# Lane Cove Council

12 November 2010  
Our ref: 48793/10  
Your ref: MP090\_0187

**Re: PART 3A PROPOSAL: 6-16 ATCHISON ST, ST LEONARDS**

North Elevation

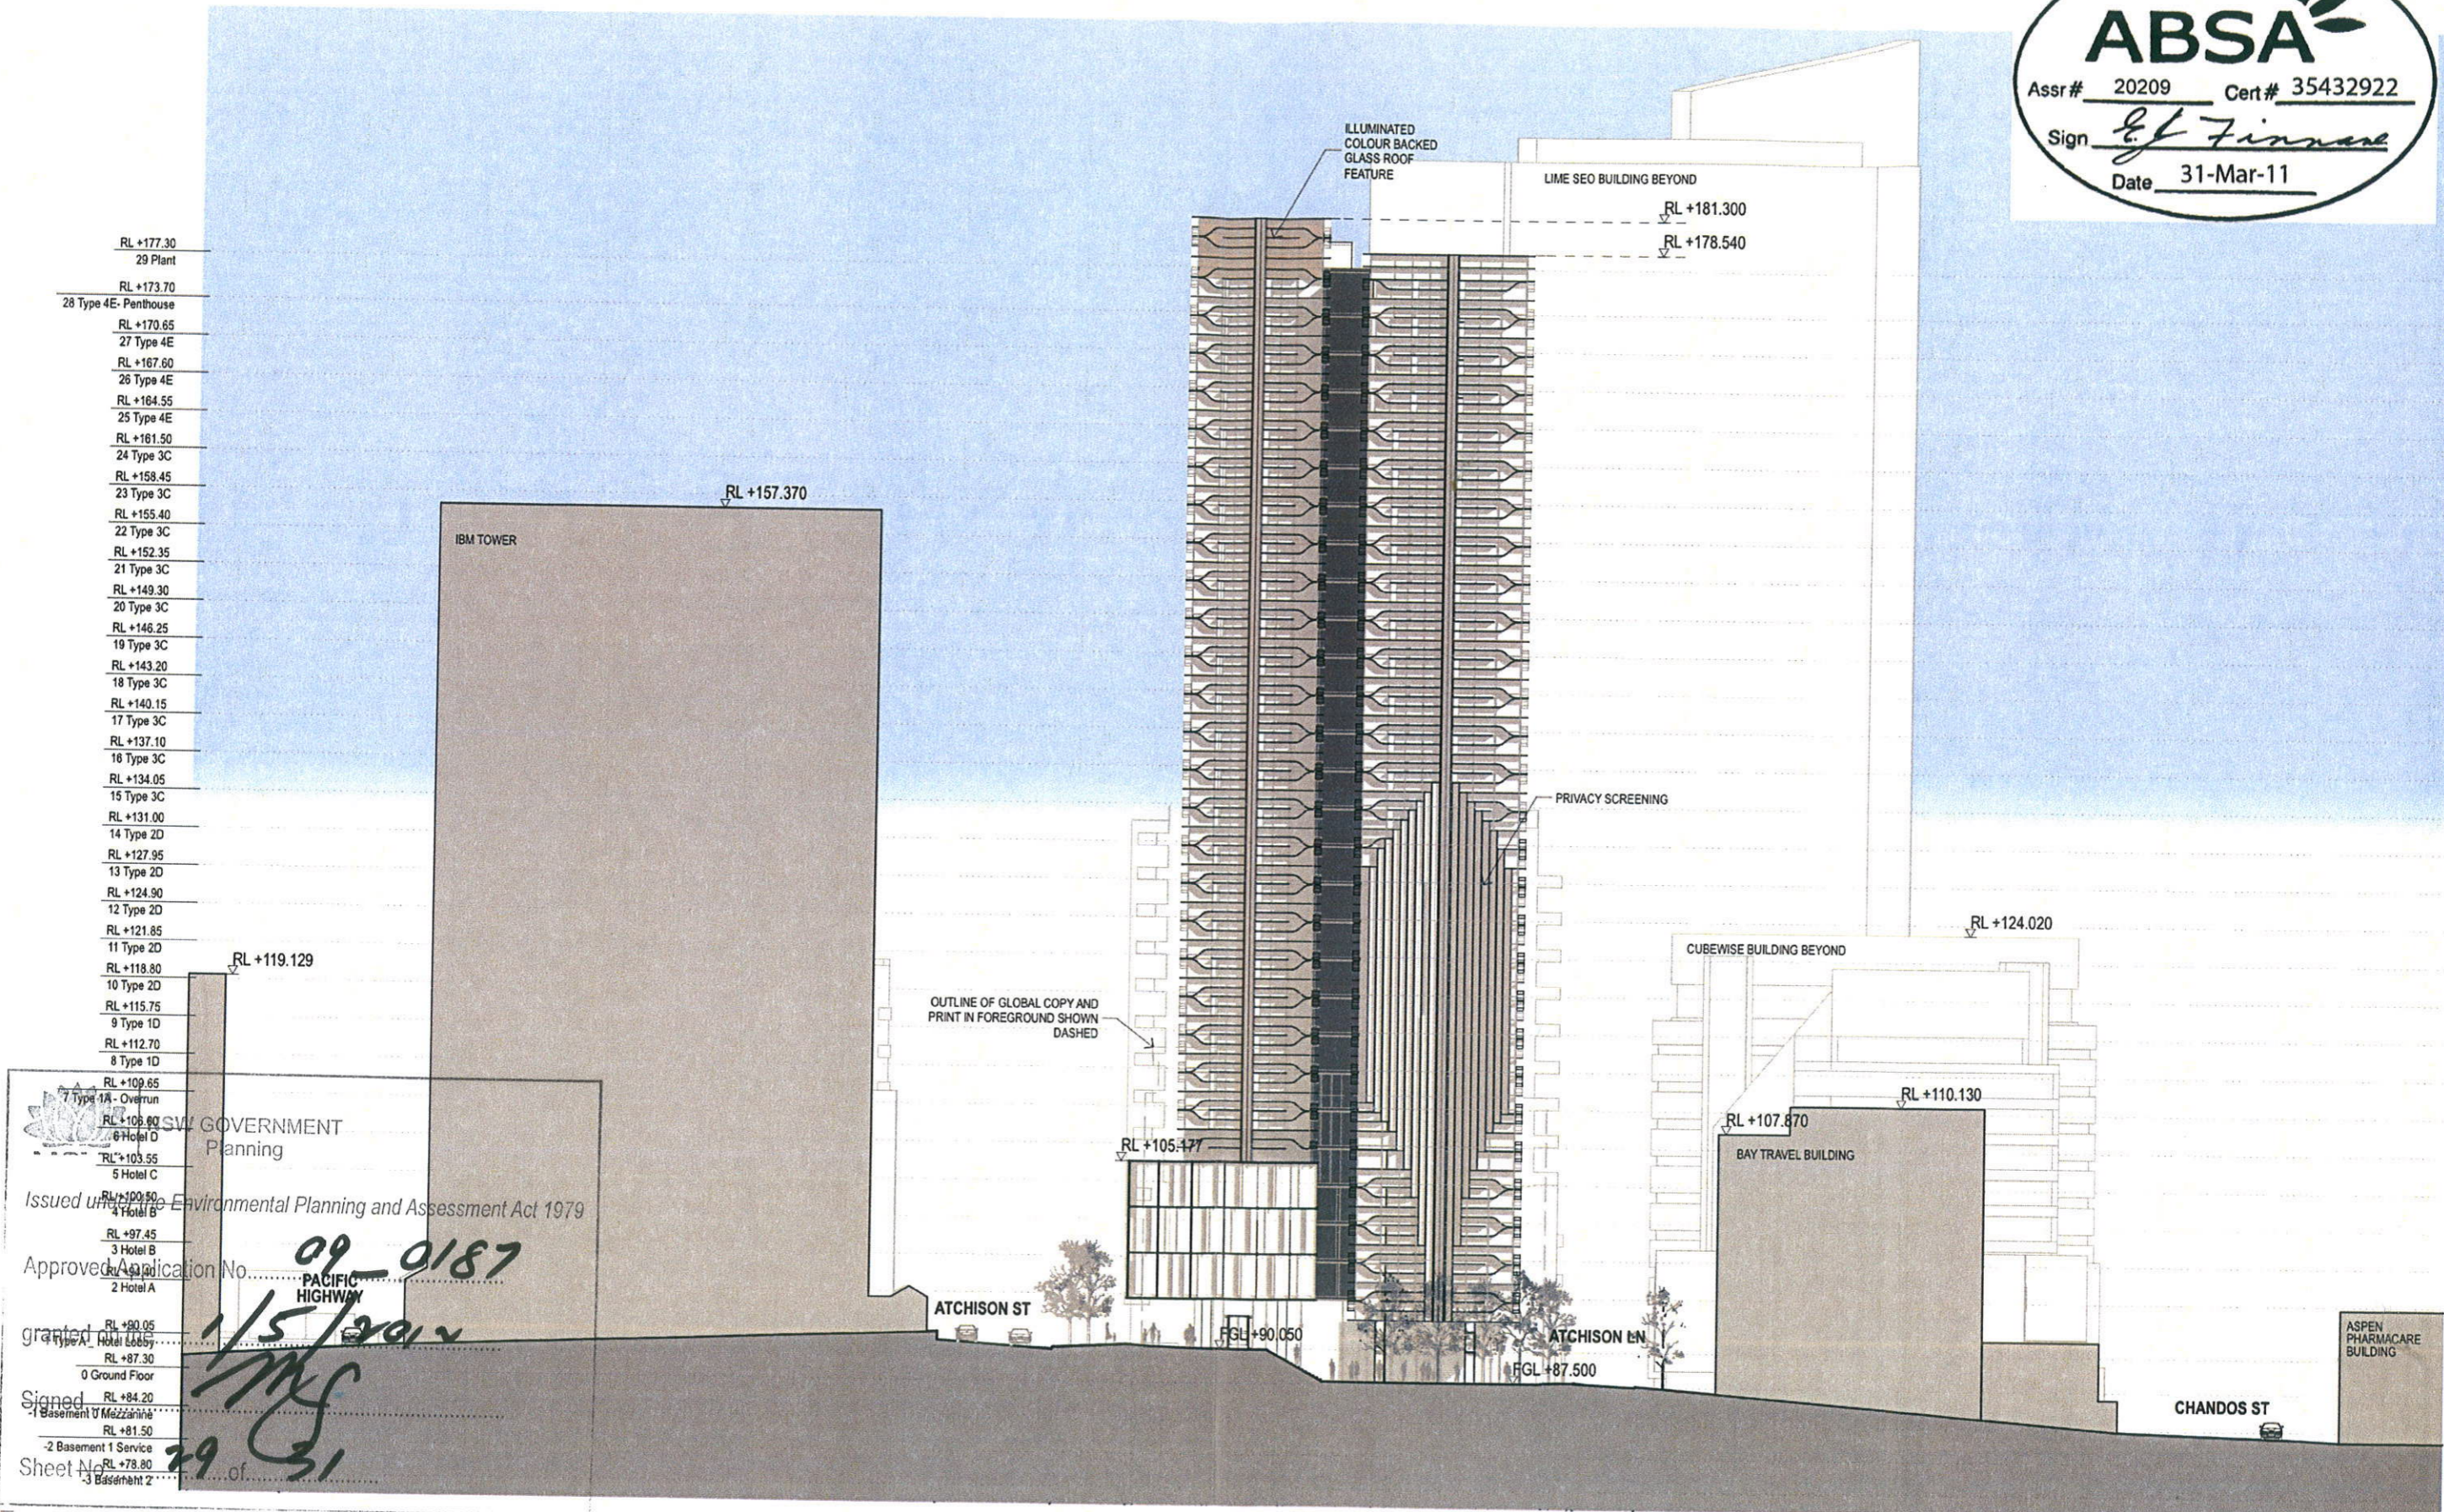
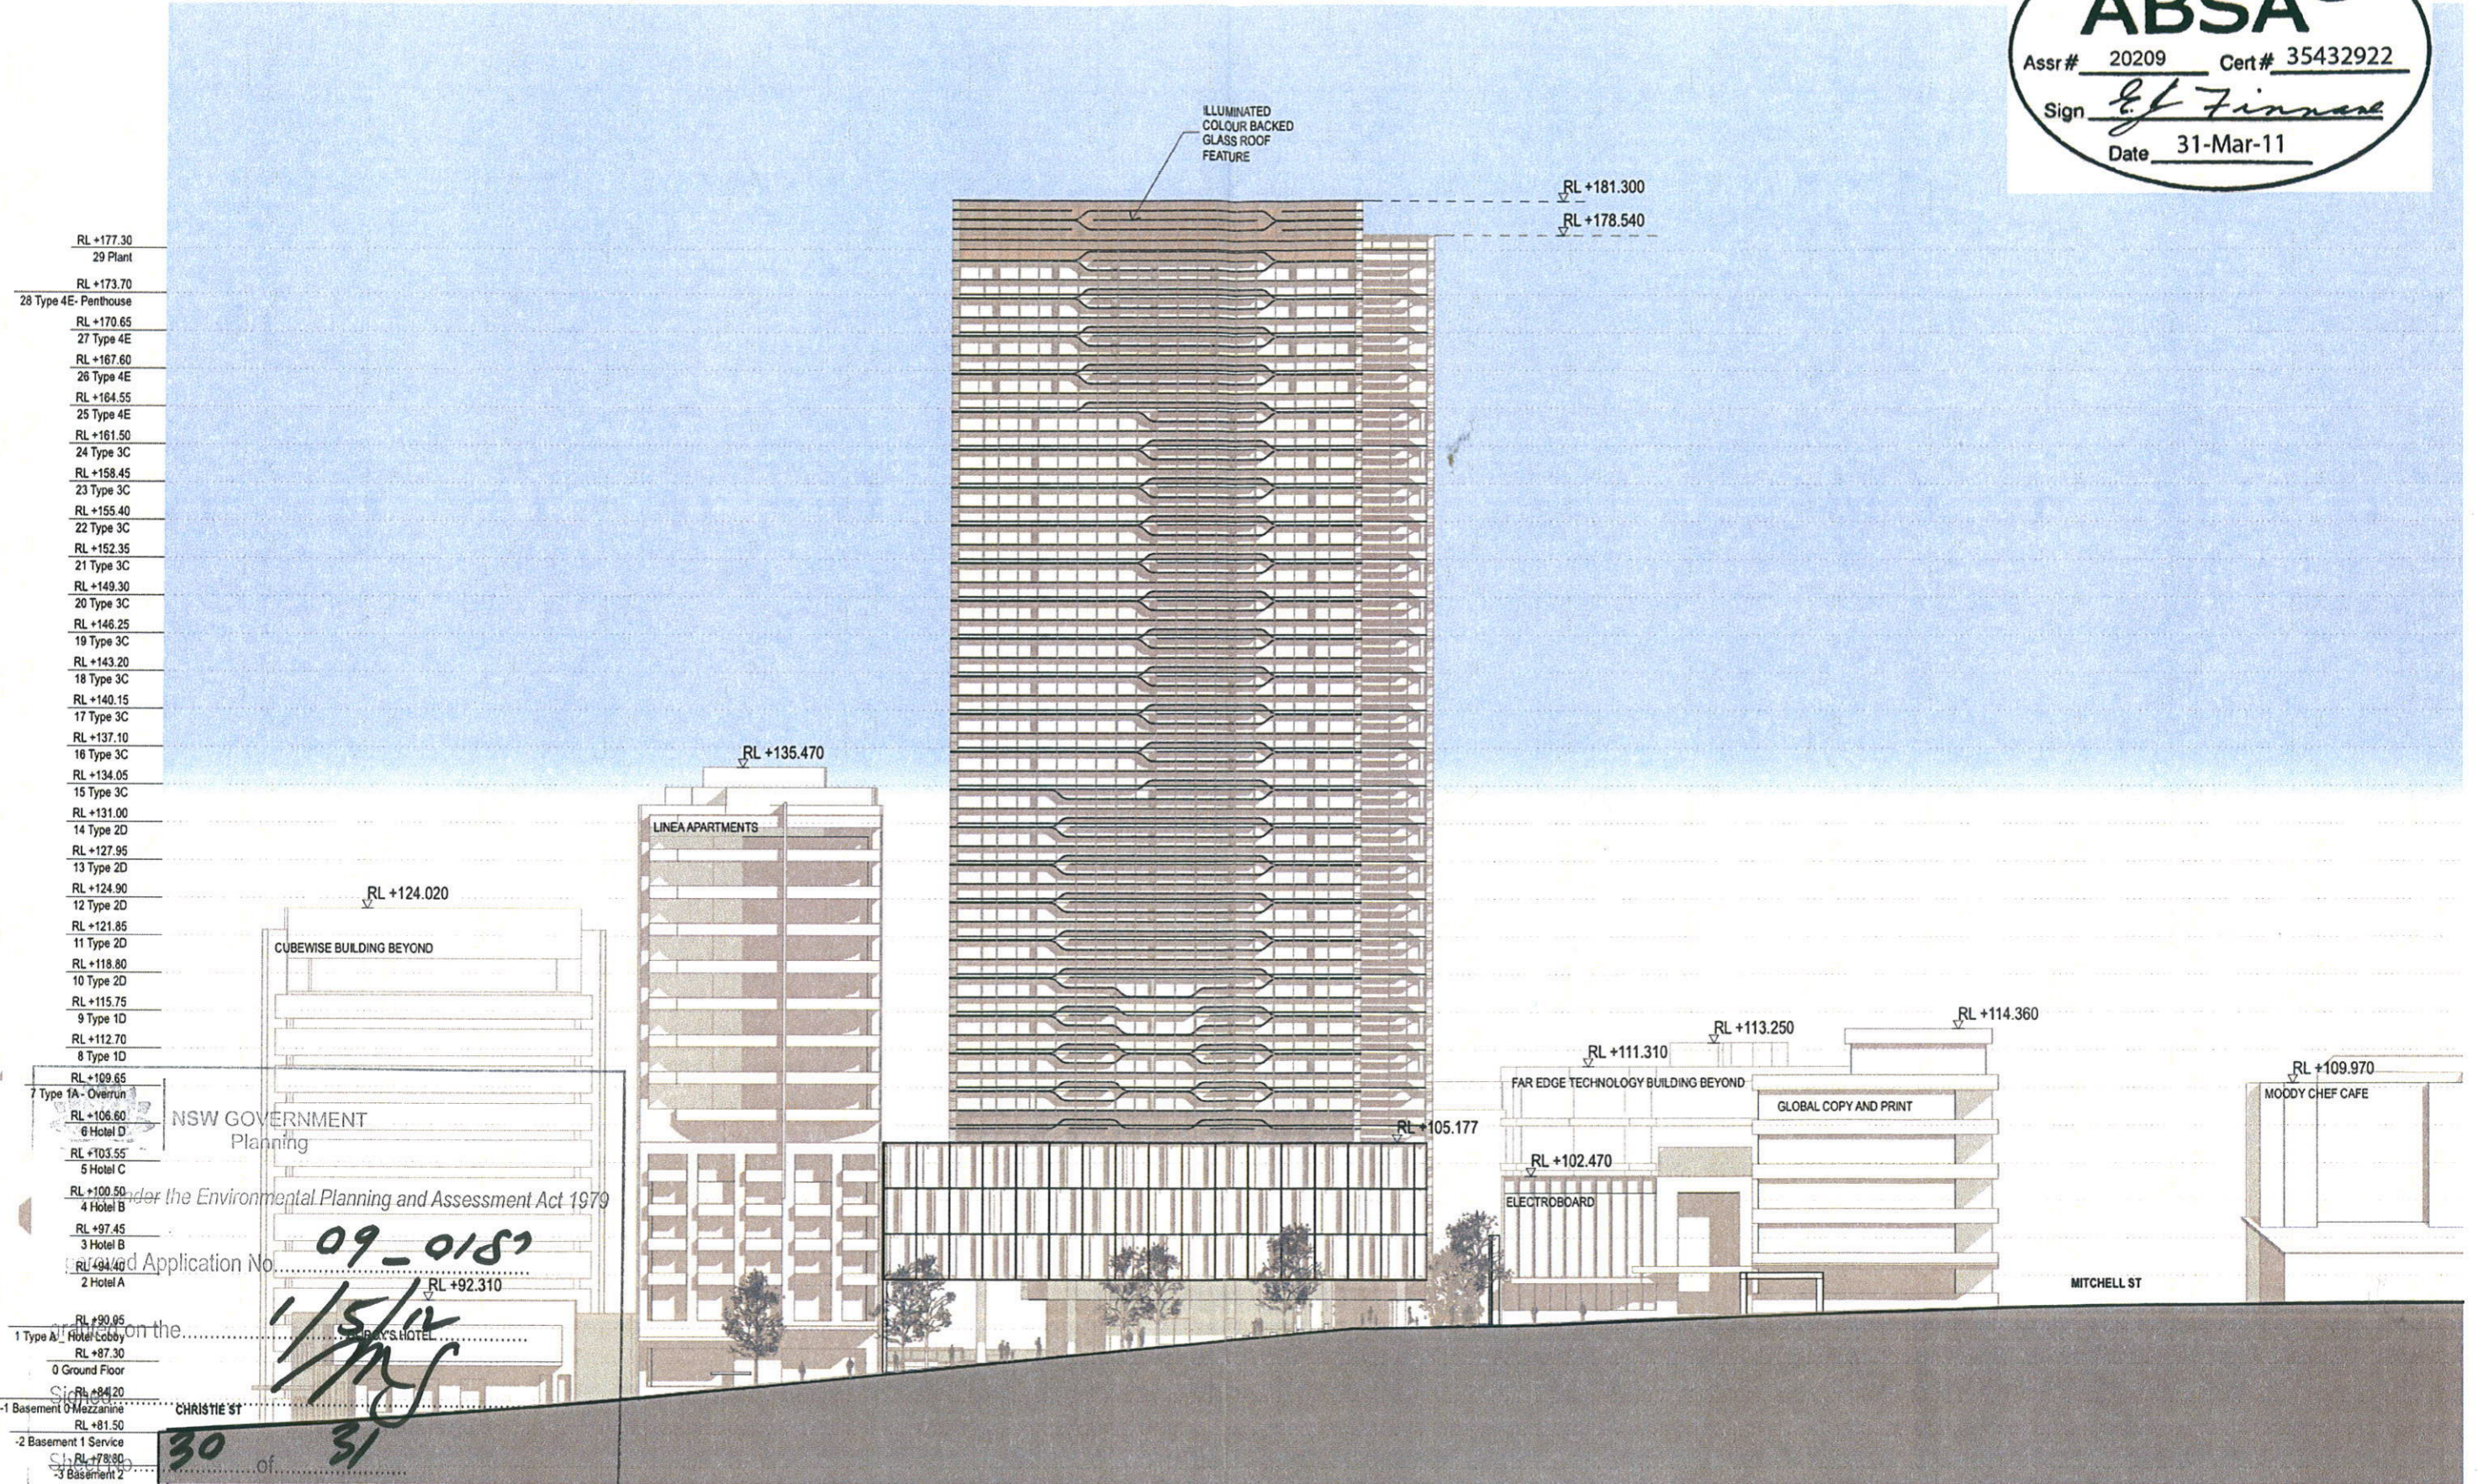
The proposal's height appears excessive relative to its context, and should preferably be reduced to a transitional scale between that of the Forum development (a stand-alone site due to its relationship with the rail corridor's history) and the heights on both sides of the Highway around 18 storeys only).

Council requests this both in terms of the centre's visual character and in order for the design to take into account the minimisation of overshadowing of residential properties within the surrounding neighbourhoods.
